2024/0662

Address: 41 White Cross Avenue, Cudworth, Barnsley, S72 8GA

Description: Removal of integral garage and erection of 2 storey front extension, and detached garage to 2 storey dwelling

PROPOSED FLOOR PLAN

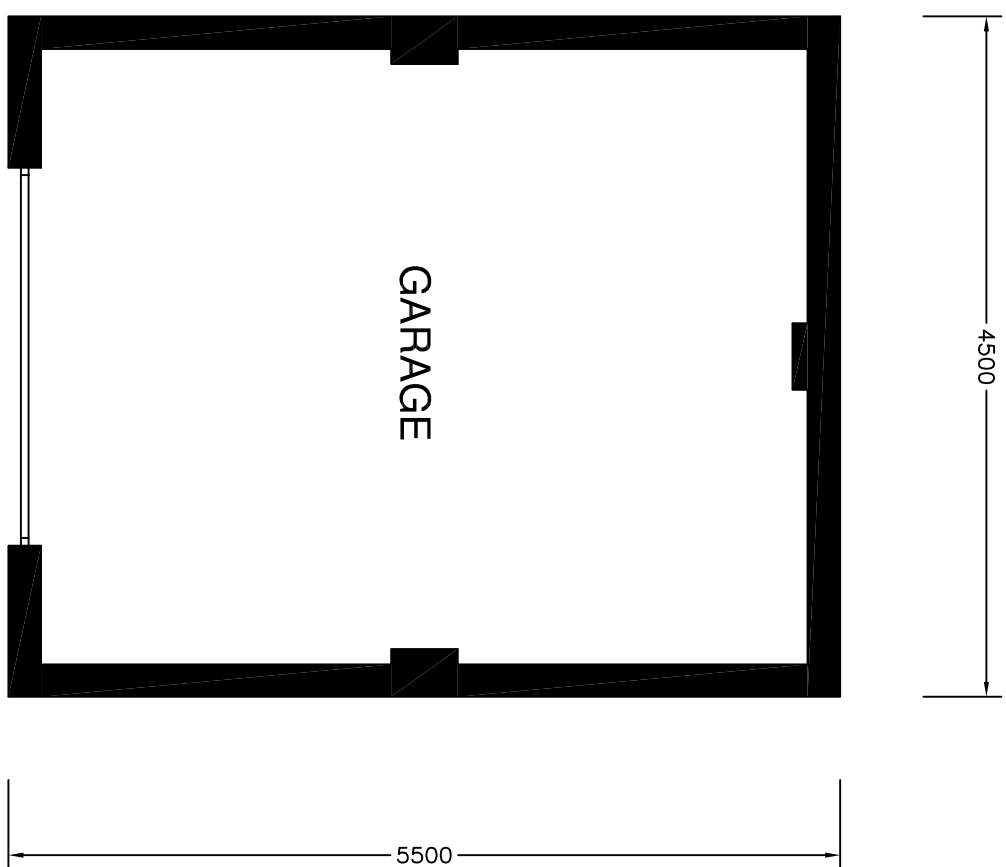
Highways DC: Whilst the number of bedrooms would be increased, the large front curtilage retains parking provision and whilst the garage is a shorter length 5.5m instead of the 6m recommended, the wider width of 4.5m would allow for storage. As such there is no objection to the proposal.

The proposed garage equally challenges the convention of may what be allowed, as outbuildings are not usually allowed in front of the principle elevation of a dwelling house. However, on the occasion, the garage would not be in-between the dwelling and the road due to its position in the street. It would be placed between the dwelling and the garden area of another dwelling and would face onto the road. It therefore does not represent a dominant position on the streetscene nor does it dominate the frontage of the property. The largest amount of usable space is at the front of the dwelling, and with the side elevation and rear garden of No.1 Orchard directly opposite the principal front elevation of the dwelling, and as mentioned previously also sat at a higher level, the front elevation and driveway of the application dwelling is unlike other dwellings on the street and generally quite unique. As such, in this case, given the appropriate scale and use of matching materials for the garage it is not considered it would cause harm to the amenity of neighbouring

dwelling or the broader street scene. With this in mind, the proposed garage in the location indicated would not harm the application dwelling, affect neighbouring dwellings or be detrimental to the character of the street scene

PROPOSED GROUND FLOOR PLAN

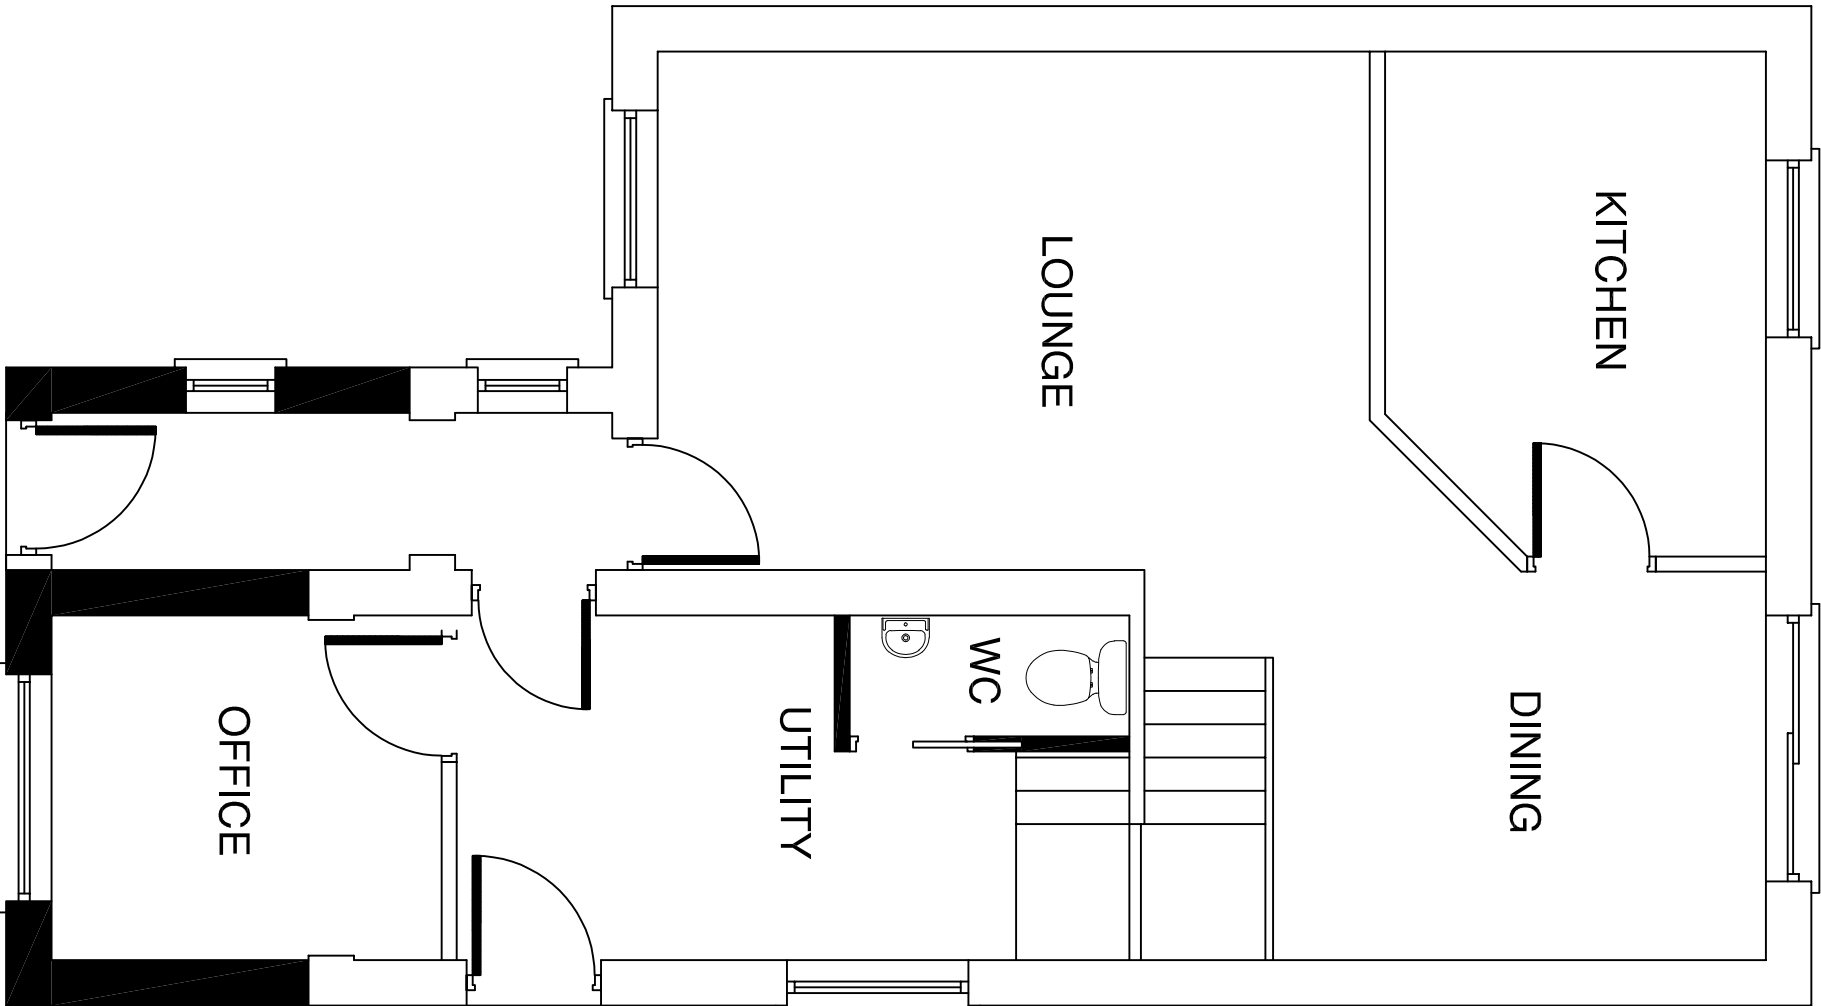
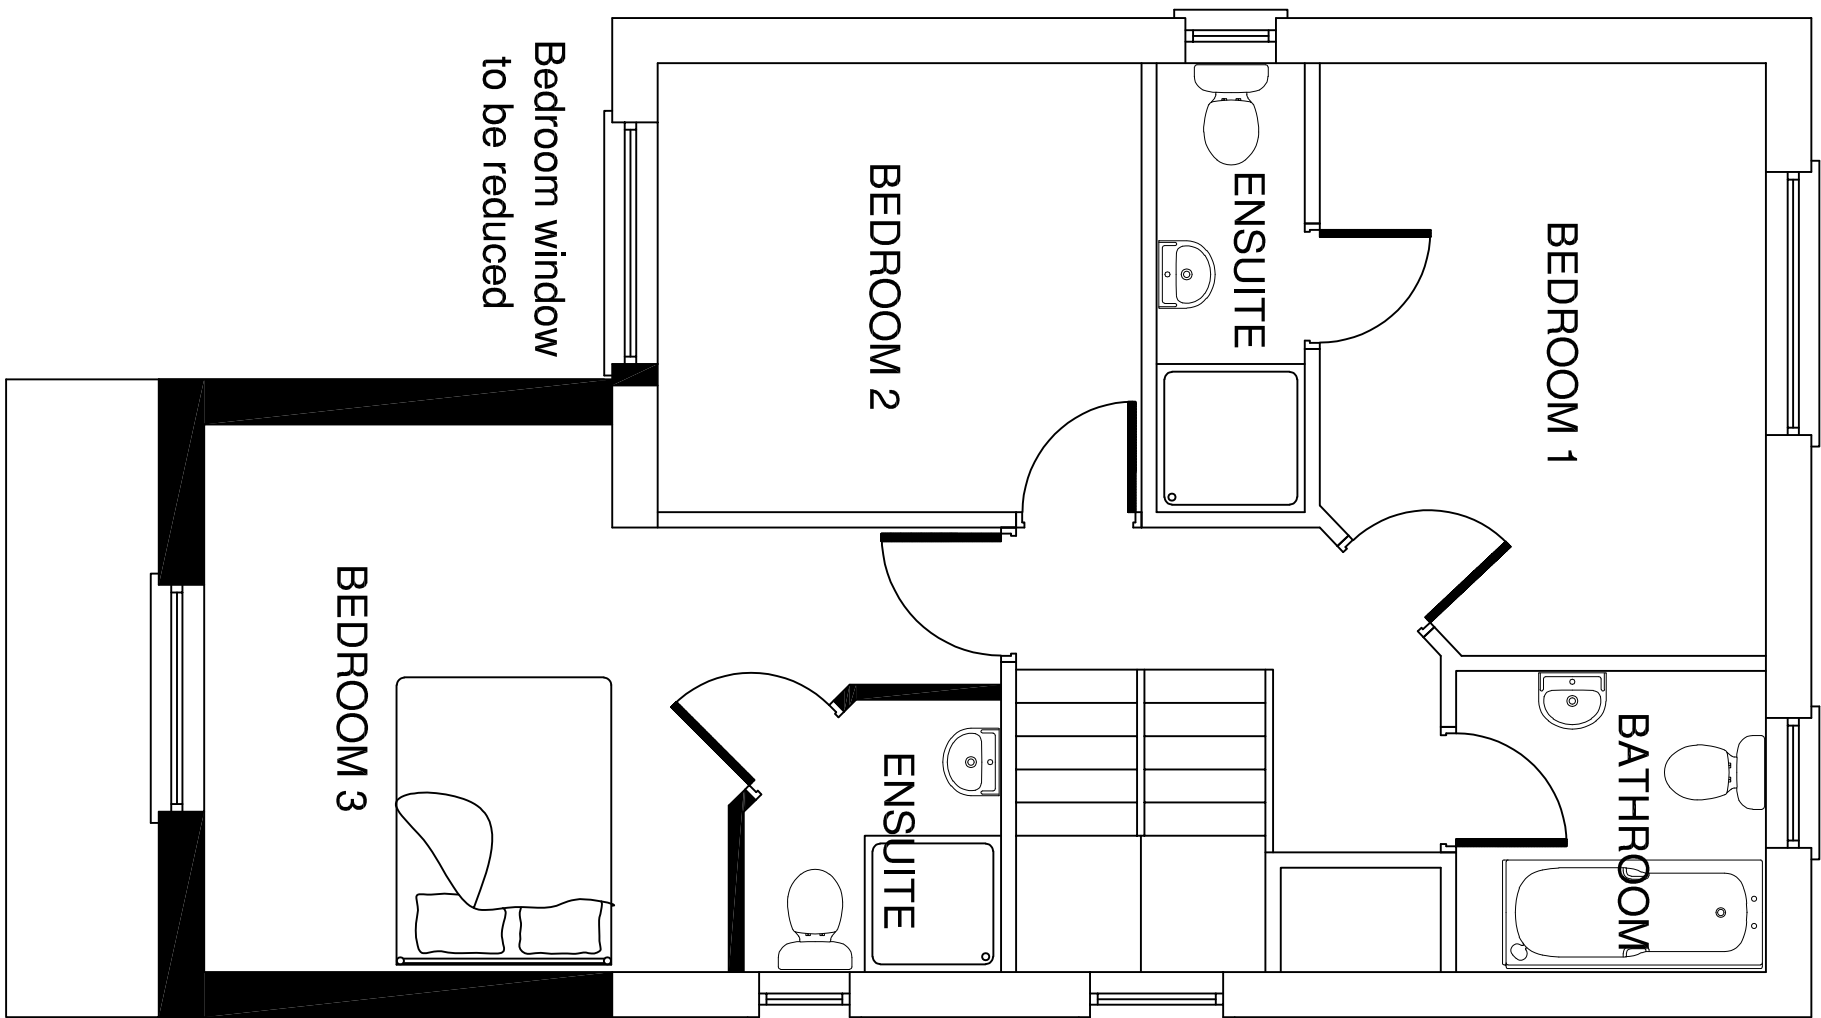
Due to the location of the proposed extension, there would be a modest impact on the amenity of the neighbouring dwelling at No.39, however with a reduced size of the first floor extension, this impact has been reduced from that originally proposed, which would have set the whole two-storey in the position where now only the ground floor aspect sits, with the first floor elevation now set back of 1m. When checking the sun path, there would be a small impact on light levels in the morning, but this period would be brief, and the existing dwelling, with its bulk and higher roof level would obscure the sun more, and for a longer period of time. In regard to privacy, there is an existing landing window on the application dwelling and a proposed first-floor bathroom window, which would be assumed but conditioned to be obscure glazed. A new entrance door is also proposed on the side elevation of the extension. As No.39 features an almost entirely black elevation on their significantly large side extension, which extends beyond the front and rear elevations, the proposed window and door would have no impact on the privacy of No.39.

It has been noted in the neighbour objection that they do not believe the proposal is reflective of local policy guidance in regard to design and impact to the original dwelling. Since the neighbour made those comments the extension has been reduced at first floor by 1m. There are other examples within the streetscene of front extensions and given the property's location, at the end of the street and not in a prominent position on the street scene, the extension would not appear as a discordant feature against either the property or the streetscene. The roof design and materials are complementary to the existing dwelling and the height is set below the pitch of the original dwelling roof to ensure it remains subordinate to the main dwelling. On this occasion whilst the boundaries of what is acceptable in relation to local policy guidance has been challenged, equally the proposal has been amended to reduce its impact and harm to both the character of the dwelling, and the broader street scene. On balance, and with consideration of strong mitigation in the unusual setting of the dwelling, the proposal has been deemed acceptable as this proposal does not cause significant detriment to the character of the application dwelling and has only a slight negative impact upon the broader street scene, which is significantly supported through the amendment to the original plans, and its position at the far end of the street.
